Application for a non-material amendment following a grant of planning permission.

Reference number:	<input type="text" value="21/01613/FUL"/>
Date of decision	<input type="text" value="19/07/2021"/>

Re-design to front door detail.

Front Elevation

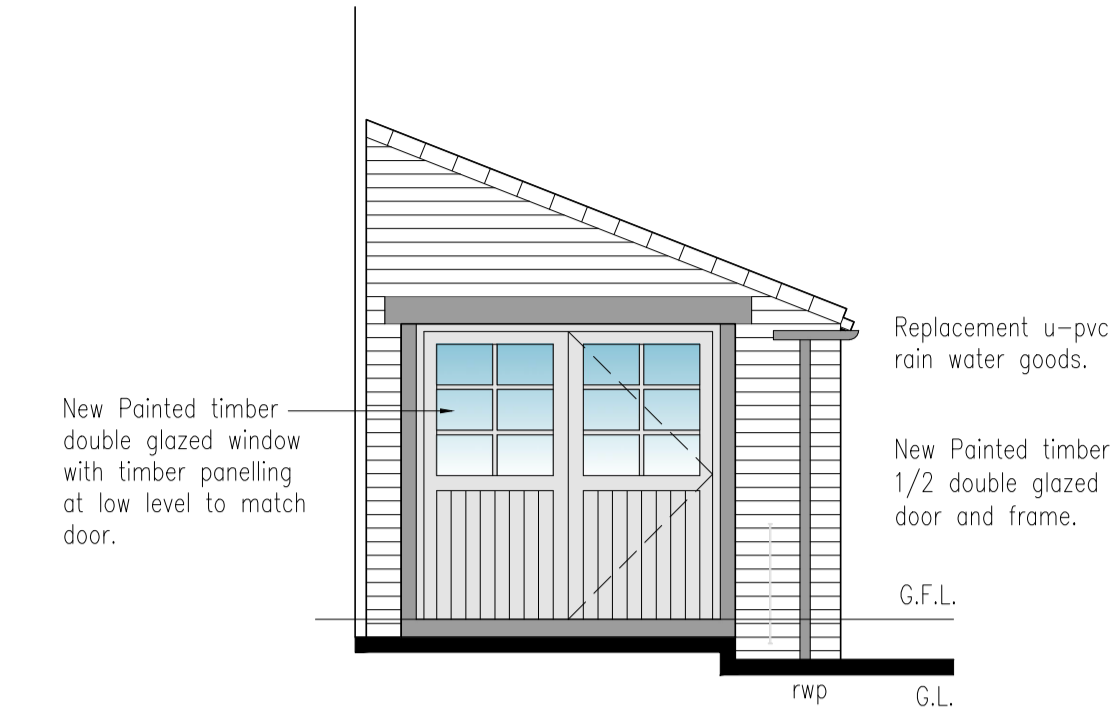
3492/01/100 B

3492/01/100 C
